ISSUES		TOTAL NO. OF TIMES RAISED	COMMENT / RESPONSE
1. TRAFFIC			
1.1	The proposed car park does not adequately cater for the possible demand - not enough car parking is proposed. The marina will greatly affect the ability of residents or their visitors to access visitor parking especially during peak times of marina operations. The car park design fails to provide essential facilities i.e. storage areas/loading areas.	82	Council's parking requirements for marinas are 0.6 spaces per wet berth, 0.2 spaces per dry berth or swing mooring and 0.5 spaces per employee. This compares to AS 3962 - 2001 which requires 0.3 to 0.6 spaces per wet berth, 0.2 to 0.4 spaces per dry berth, 0.3 to 0.6 spaces per swing mooring and 0.5 spaces per employee, plus one space per 30m2 for ancillary activities not related to boat berthing. AS 3962 - 2001 notes that 0.6 spaces per wet berth should be considered for racing clubs, and 0.3 for commercial facilities such as the proposed development. Council's parking requirement is therefore not considered to be appropriate as the proposed development is not a racing club marina. The proposed 58 space car park satisfies the Australian Standard and is therefore

PLAN
MANAGER'S OFFICE
Scale 1:100

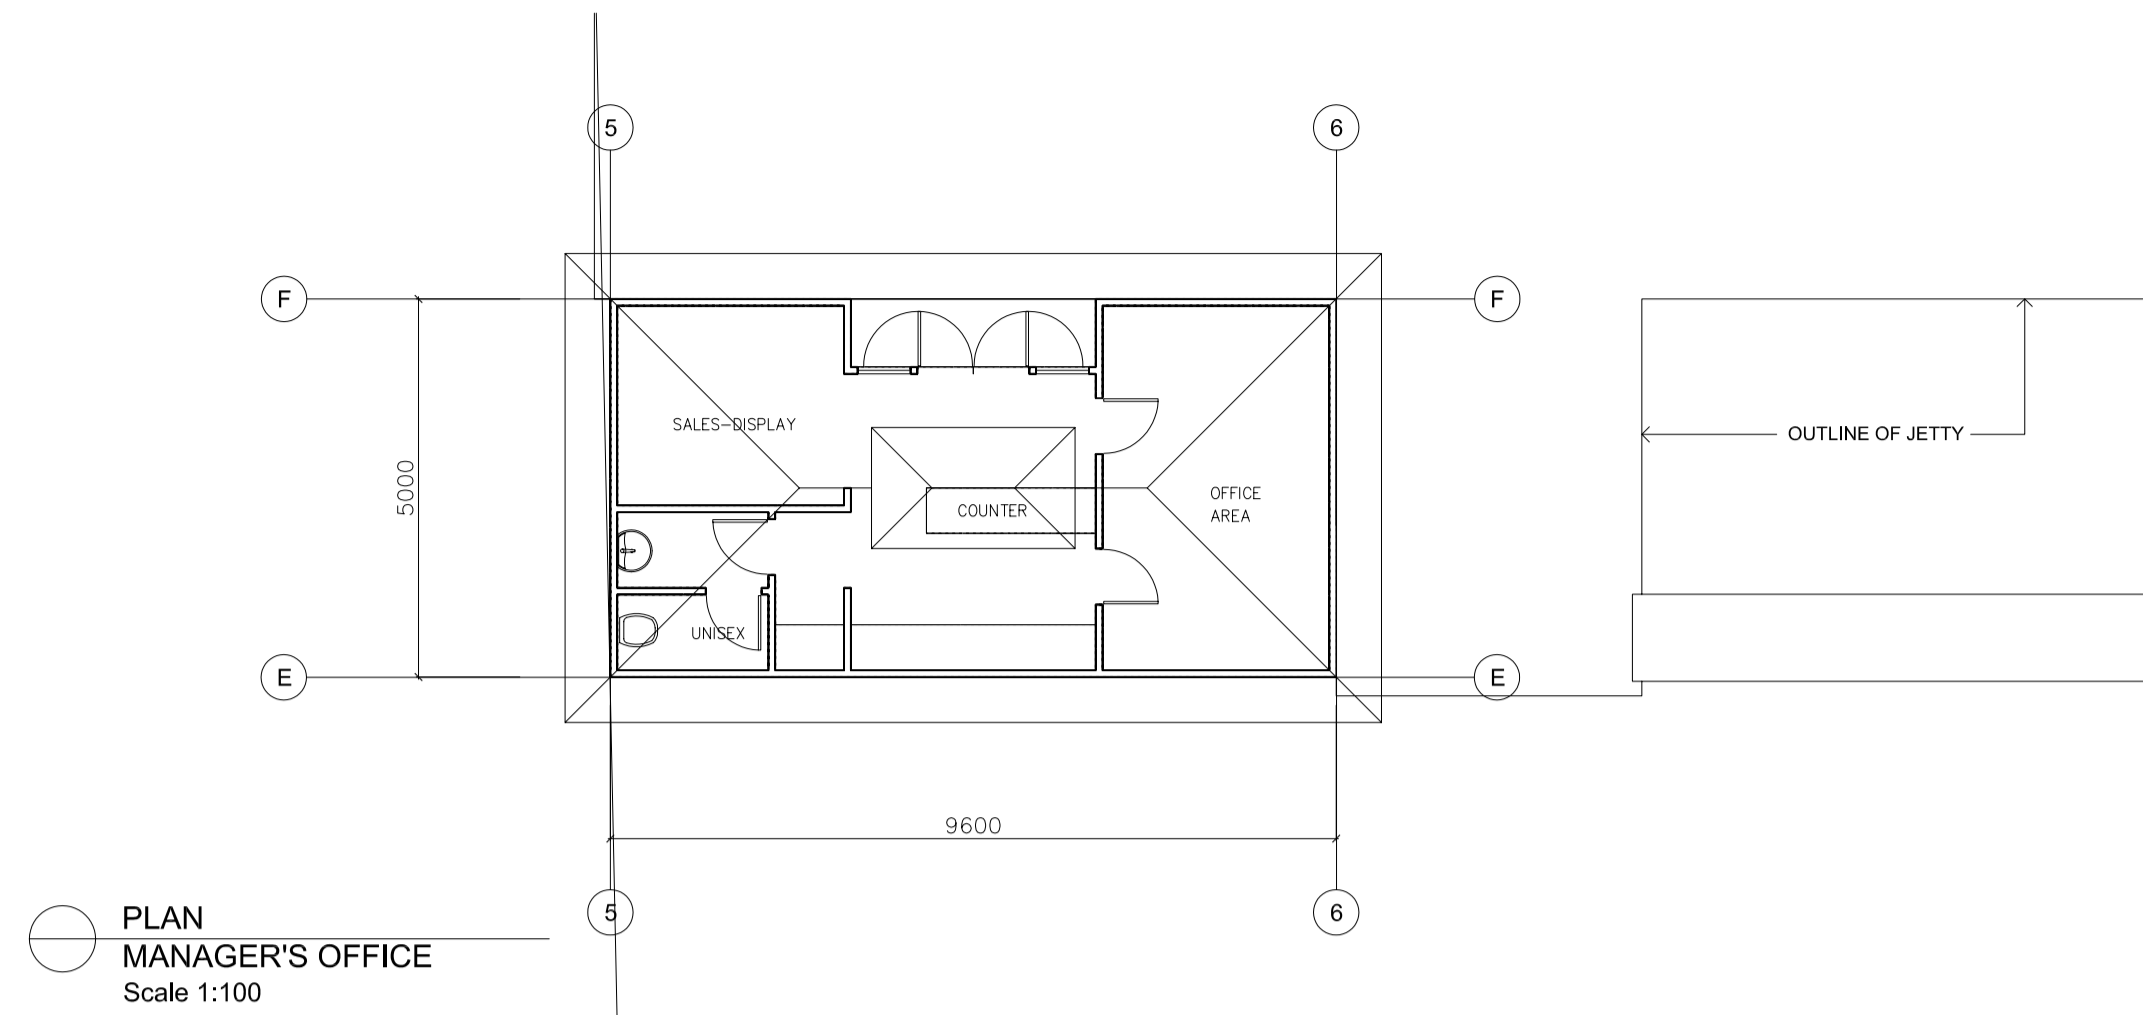
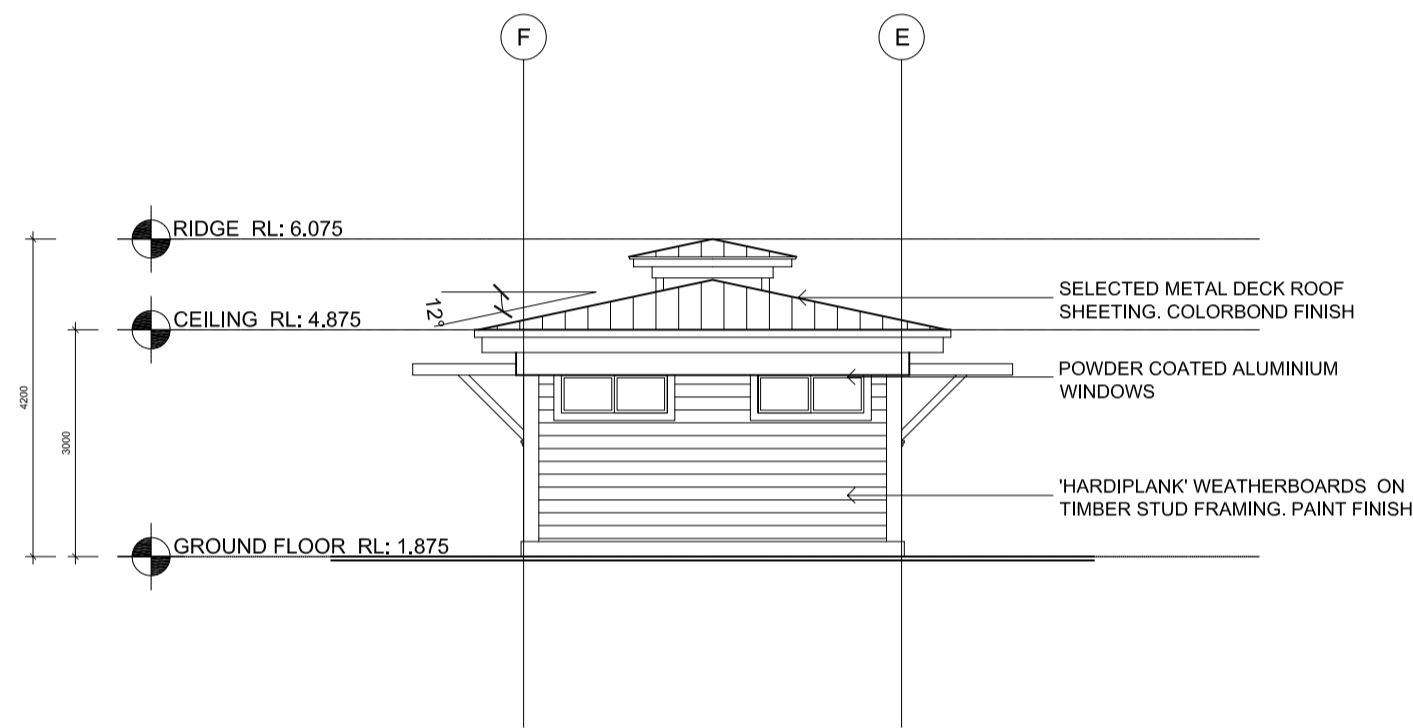
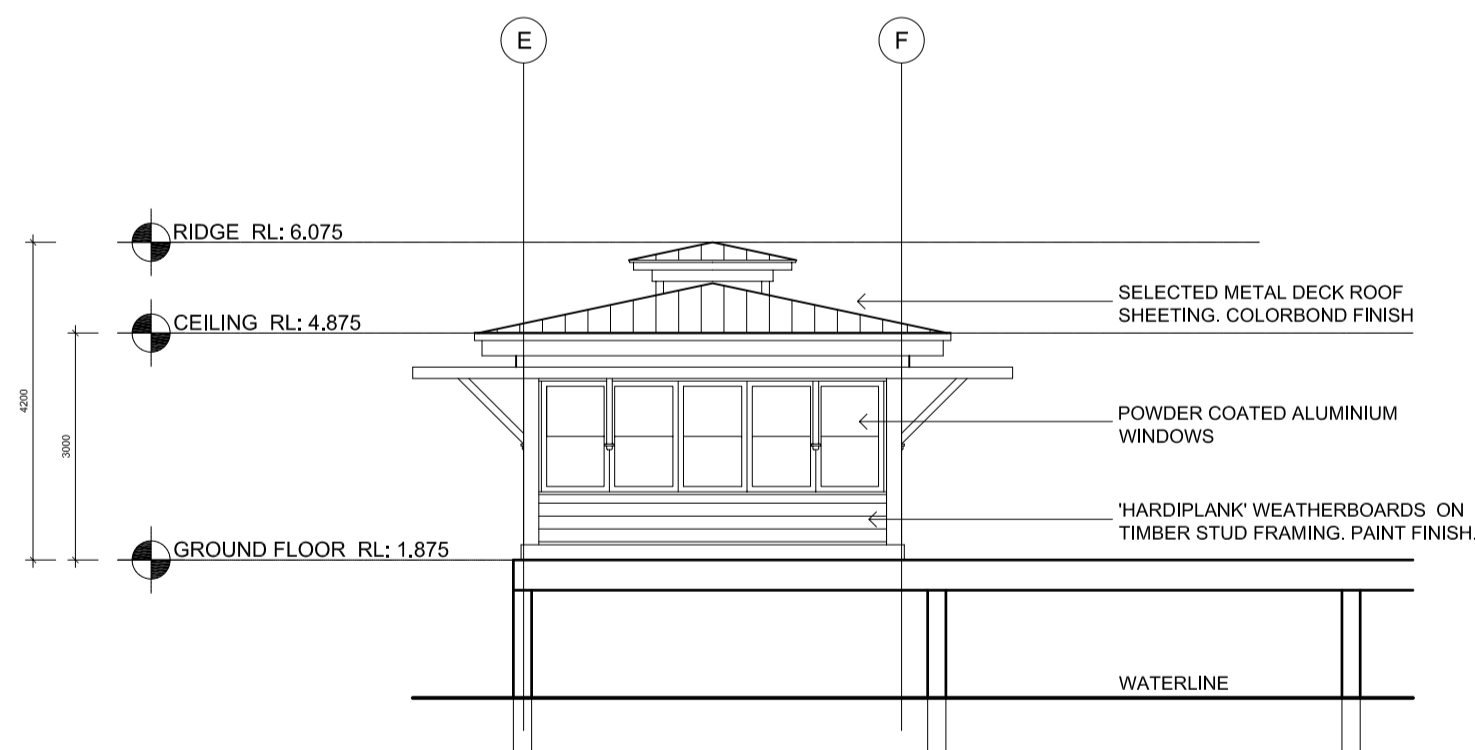
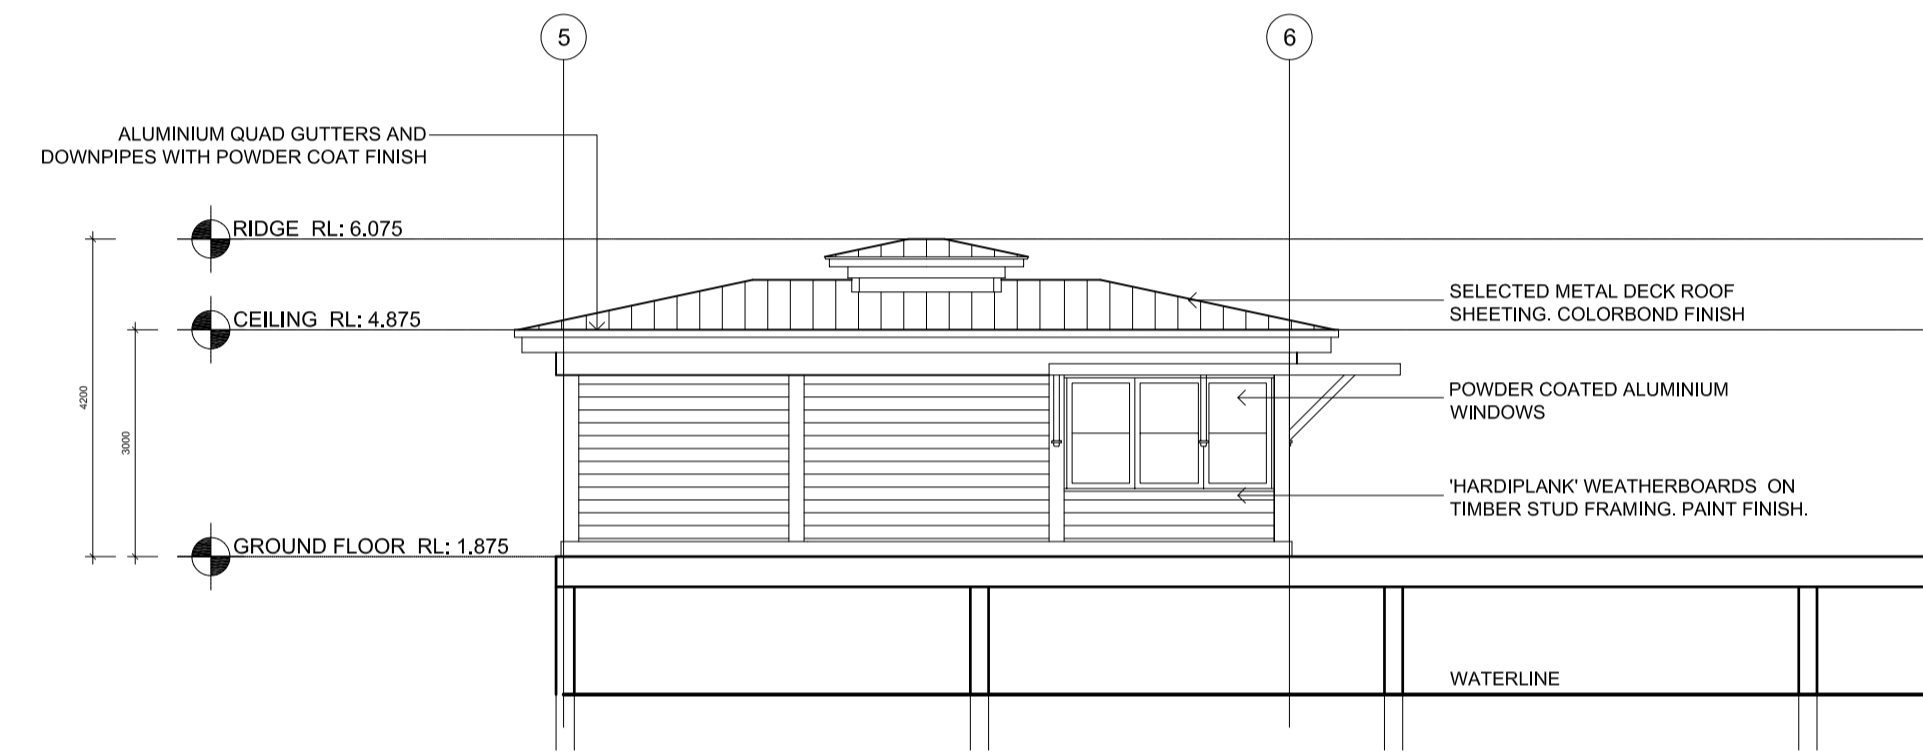
2.16	The area under the proposed manager's office has been identified as a toxic 'hot spot' but would not be covered by the geotextile blanket. The proposal does not provide any plan or give any commitment to remediate this area prior to construction. How are the pollutants to be restrained in the 10m area between the shoreline and the blanket commencement including one untreated 'hot spot'?	2	<p>The 'hotspot' referred to is 'Area B' to be remediated by Jemena (refer to Figure 2 in the URS report titled Preliminary Environmental Assessment, Remediation of Sediments in Kendall Bay, Mortlake (dated 30 October 2008)).</p> <p>Should the Jemena remediation not have been undertaken before the marina is ready to be constructed then modifications can be made to the jetty design to span over the 'hot spot' area to be remediated by Jemena and enable access to the remediation area for Jemena. The modified design could involve the western end of the jetty (5m wideX20m long) being removed in two sections, each 2.5m wide, with no piles in the area to be remediated by Jemena and Jemena may still have access to undertake their remediation works.</p> <p>GBA Coastal (GBAC) has confirmed that the zone between the seawall and the SPS blanket ranges in width from 15m to 20m and is approximately 300m long. Once the SPS and marina is in place, minimal change in wave energy will occur (<1% at the western shoreline). The only potential for sediment mobilisation in this zone (which includes the 'hot spot') would be due to the passing of fast ferries, which is no change to the current conditions.</p>

INDICATIVE PLAN THROUGH BLANKET

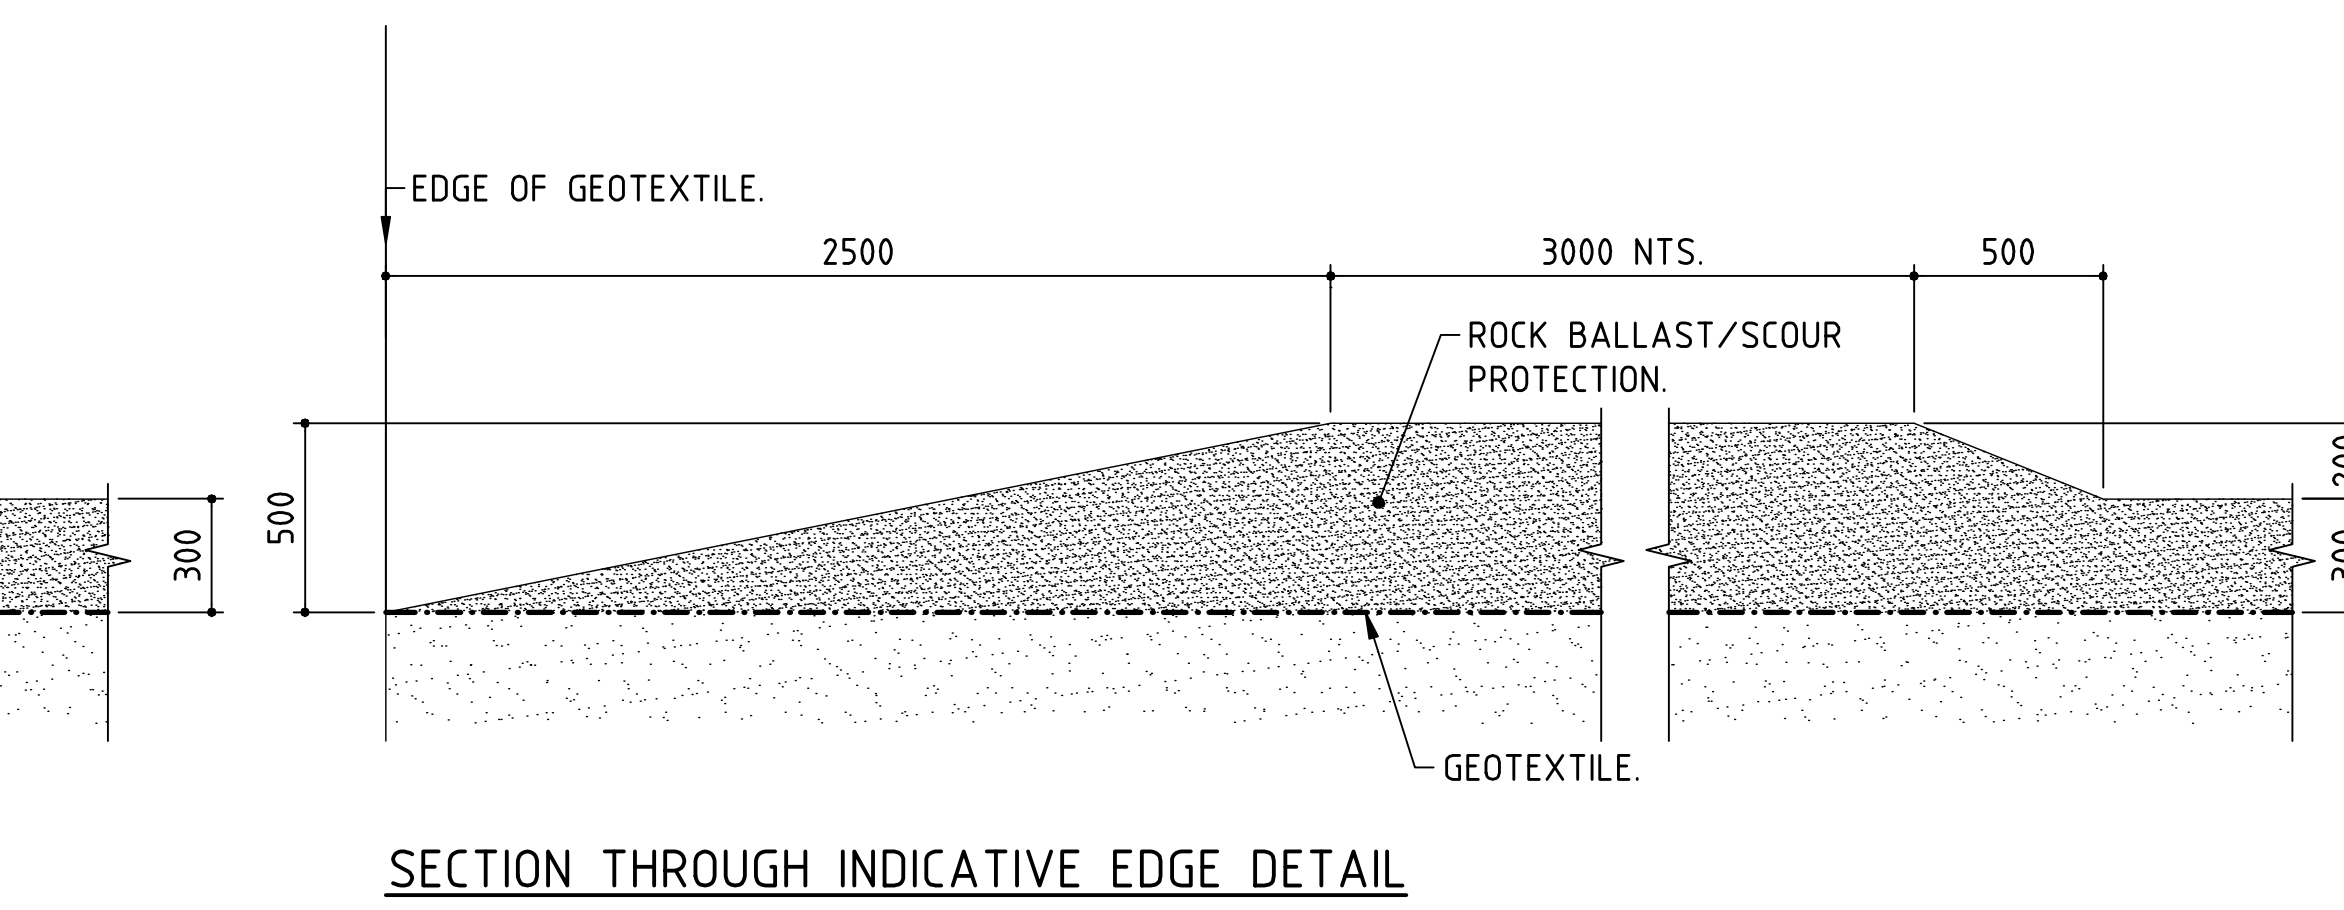
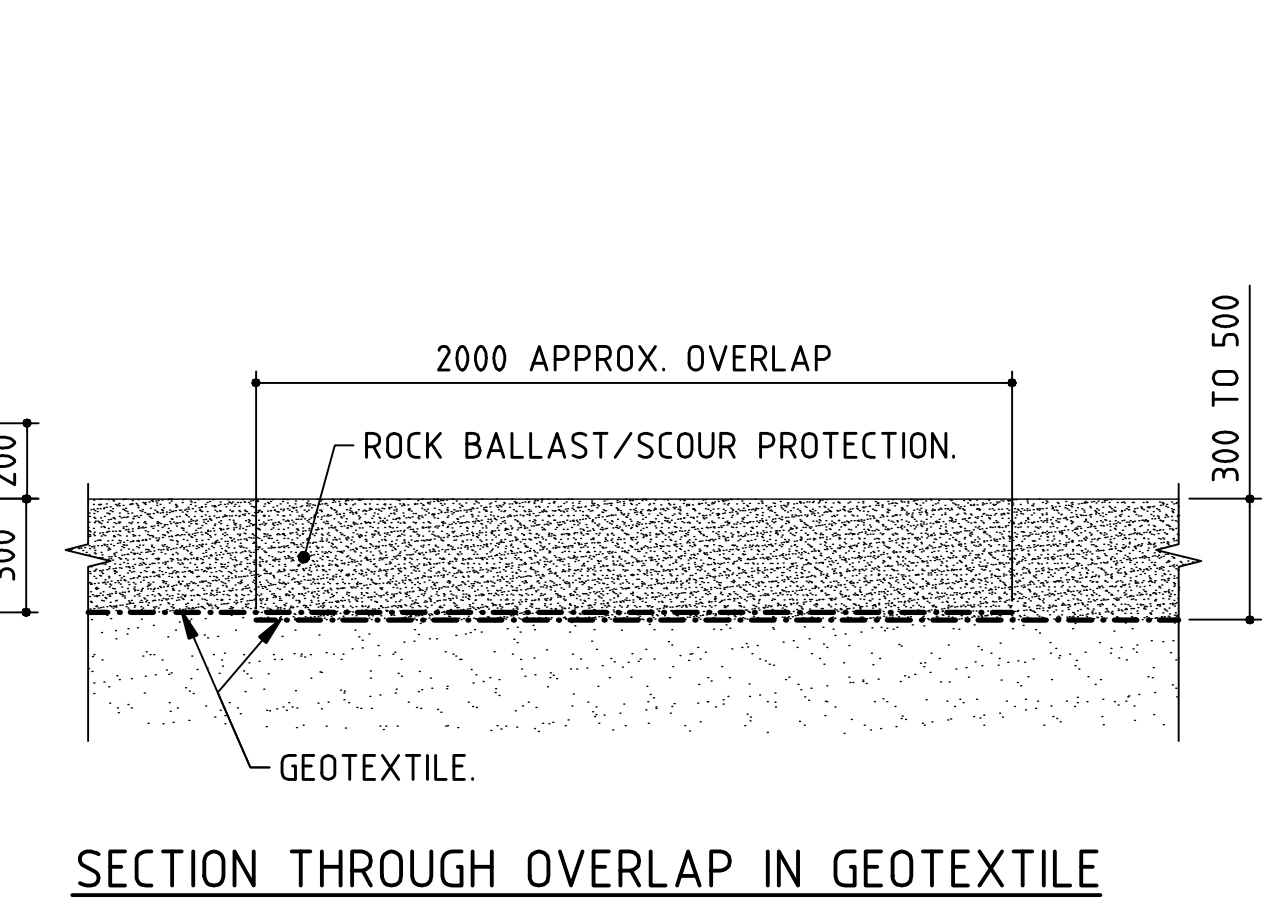
2.5	The movement of piles following mooring will result in dispersal of pollutants above the geotextile blanket. Are piles to be driven before or after the geotextile material is laid? How much pollutant will be released in the process? No reference is made to the methodology of withdrawing at least 13 temporary piles following construction.	5	<p><u>During construction of the marina:</u></p> <p>Temporary piles (for the securing of the silt curtains and for mooring of barges) will be driven prior to the laying of the geotextile. The movement of the pile will be downward with a small degree of lateral movement. The quantity of sediment disturbed will be minimal and any sediment which is released into the water column will be contained by the silt curtains (refer to AECOM Construction Environmental Management Plan (CEMP))</p> <p>In relation to the construction of the permanent piles, the geofabric blanket and rock armour will first be placed on the seabed. Blockouts will locate the surveyed position of each of the piles within the rock armour. When the blockouts are removed divers will make slits in the geofabric. The piles will be driven through these slits in the geofabric. On driving the piles the quantity of sediment disturbed will be minimal and any sediment which is released into the water column will be contained by the silt curtains (refer to AECOM Construction Environmental Management Plan (CEMP)). Divers will then install a geotextile collar around the base of the pile on top of the geotextile blanket. The collar will be attached to the pile and will move with it. At the collar there will be two layers of geotextile covered by the rock armour (Refer to Drawing DA06- Bed Treatment prepared by TLB Engineers in Appendix 1, Volume 2 of the EA). These geotextile collars will prevent movement of sediments into the water column..</p> <p>The proposed installation procedure is set out in the Construction Management plan included in the EA as Appendix 12.</p> <p>Withdrawing of temporary piles: The approach will be same as that used during demolition of the former coal wharf. It is noted that during the pile removal works, no free phase contamination was identified. More than 100 piles were removed when the original wharf was removed. The construction procedures used were approved by the DECC and environmental controls used successfully to prevent the dispersion of contaminants.</p> <p><u>Operation of the Marina</u></p> <p>The movement of piles in service at the bed, as a result of wave action or contact with boats, will be small (in the order of 10-20mm) . Movement of the piles will be laterally, there will be no vertical movement of the piles. Movement of the piles will not result in the discharge of pollutants which exist at depth in the sediment profile.</p>
